The North Falls Offshore Wind Farm project (EN010119)

Babergh District Council submission to procedural deadline 7

This is the submission of Babergh District Council to deadline 7 of the examination for the North Falls Offshore Wind Farm project (EN010119) consisting of Babergh District Councils' responses to ExQ3.

Document Reference:	9.30
Volume:	9
Date:	May 2025
Revision:	2

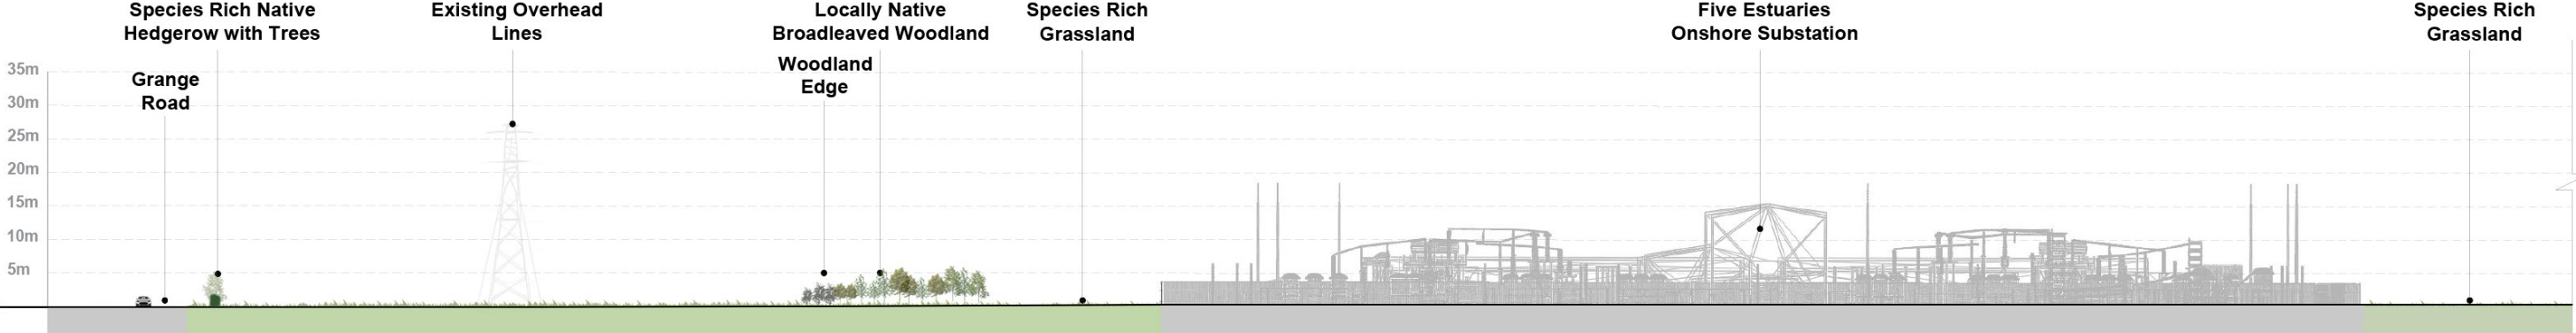
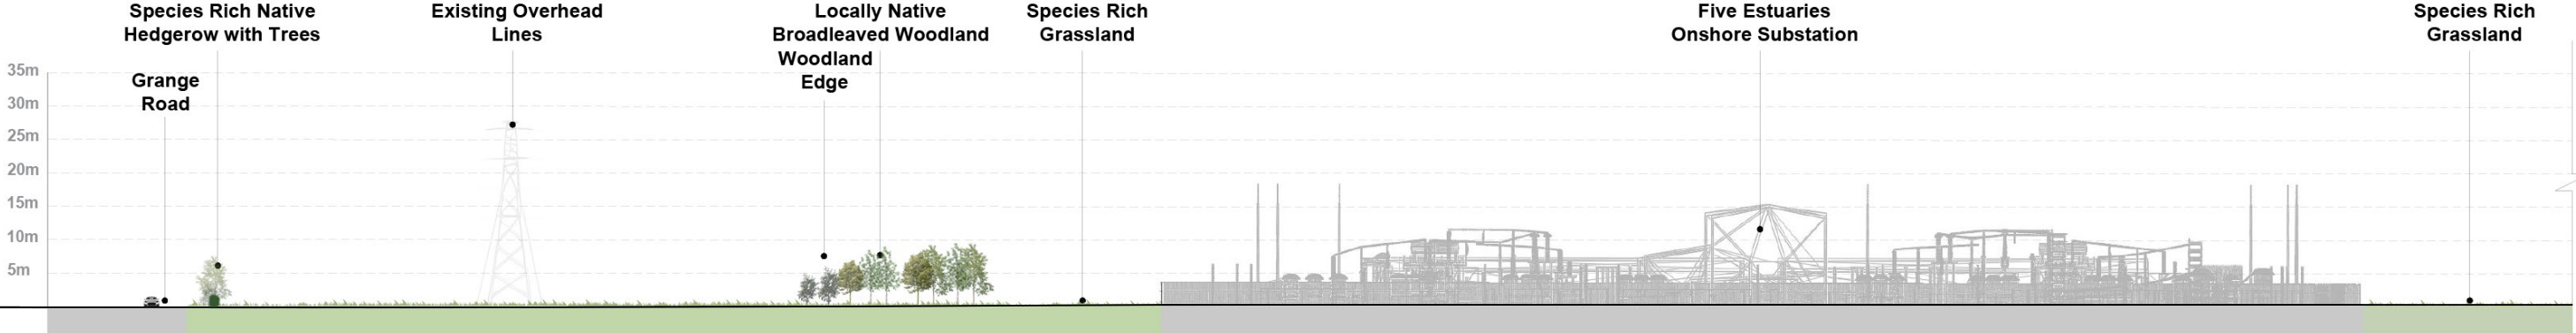
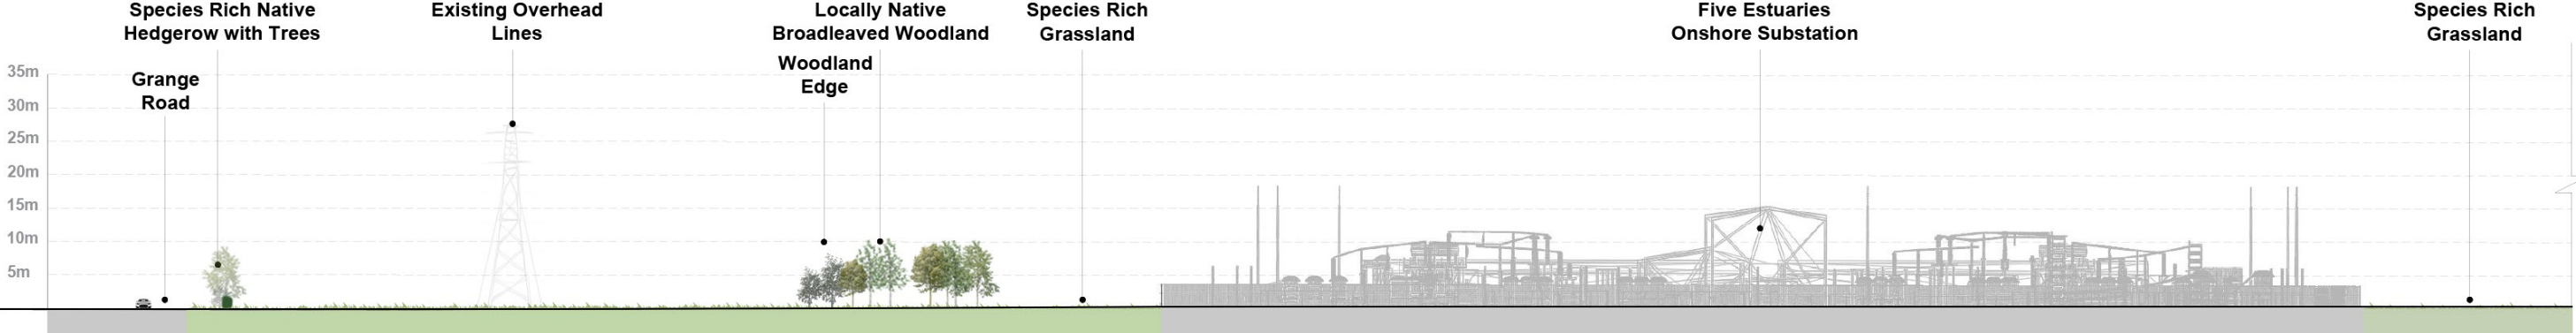
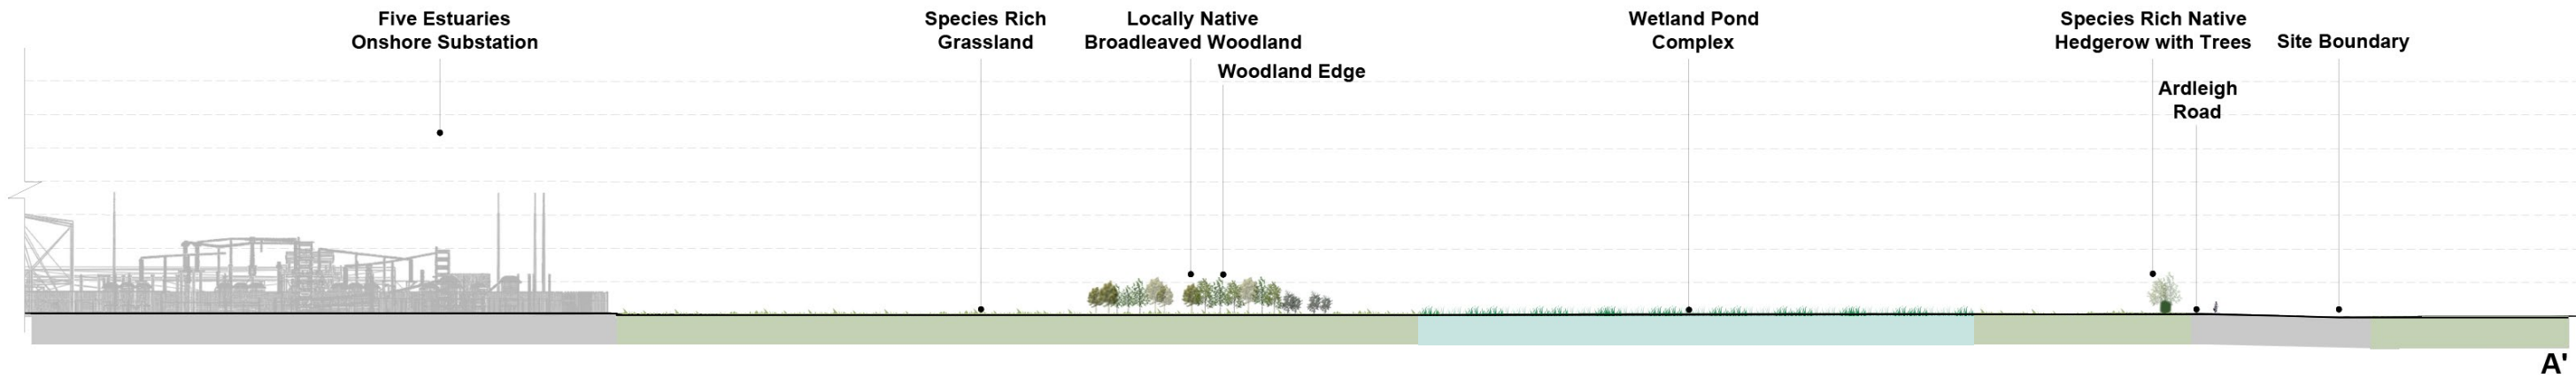
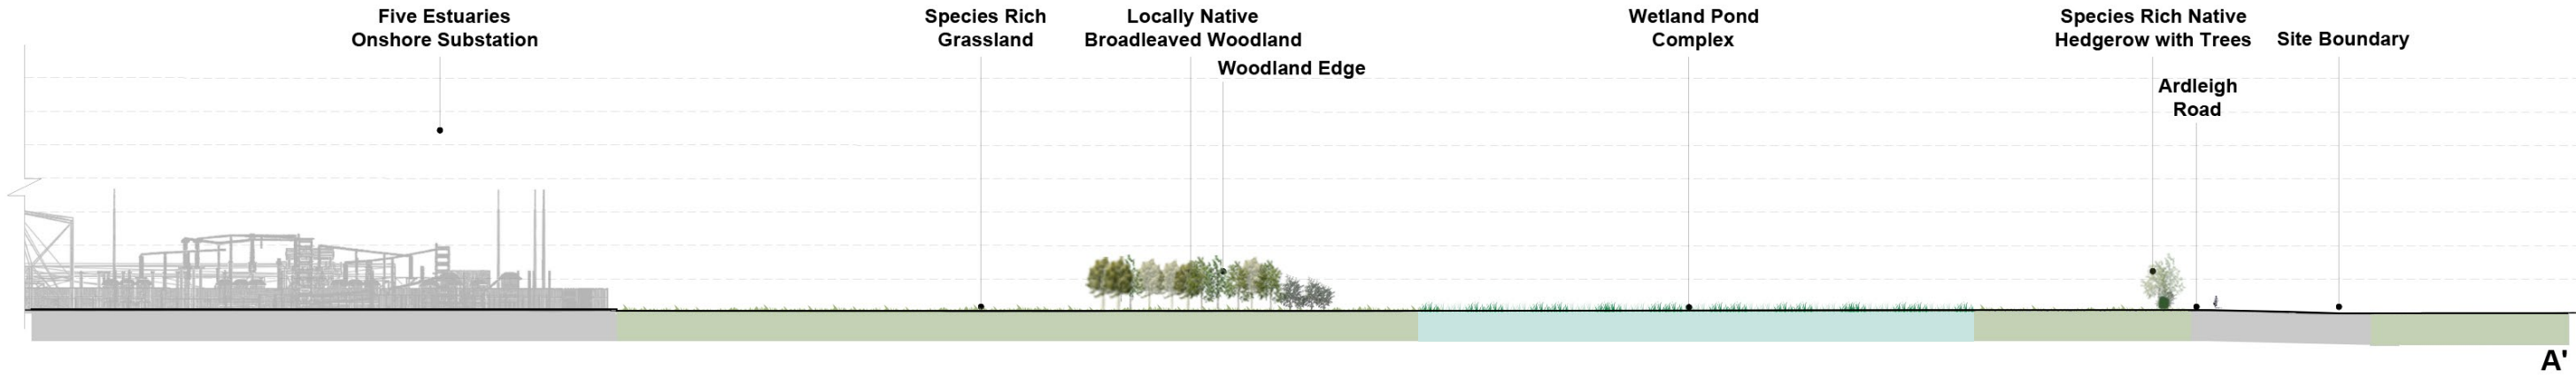
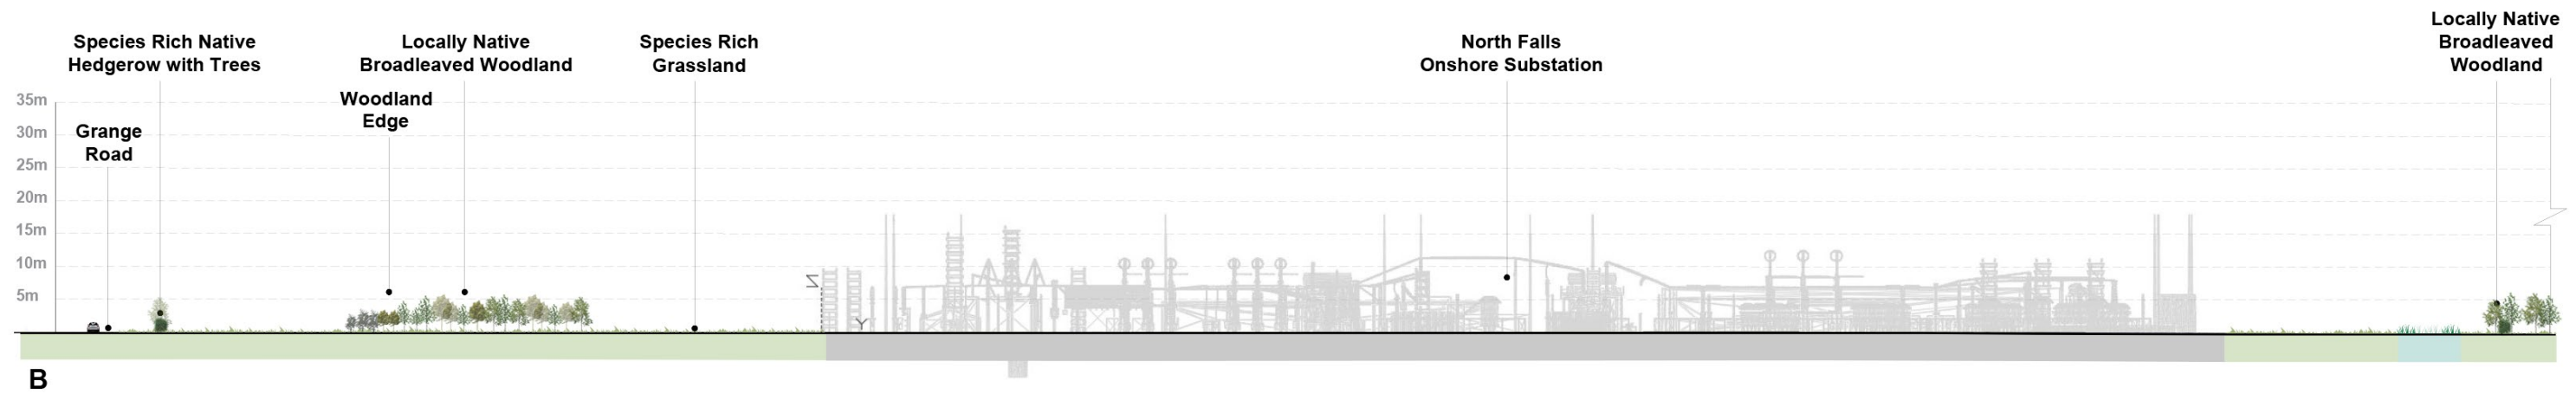
The Council understands that the applicant has estimated that the woodland/shelterbelt planting will reach approximately 6-8m after 15 years. The Indicative Planting cross-sections at the onshore substation (Rev 2) [REP5-035) and the visualisations supplied with the ES demonstrate that the proposed planting never fully conceals the substation.

The Council is concerned that without appropriate scaled drawings being required to associate with the Final LEMP, the full intention of the proposed landscape strategy and its successful implementation at the delivery stage cannot be guaranteed and risks not being successfully delivered.
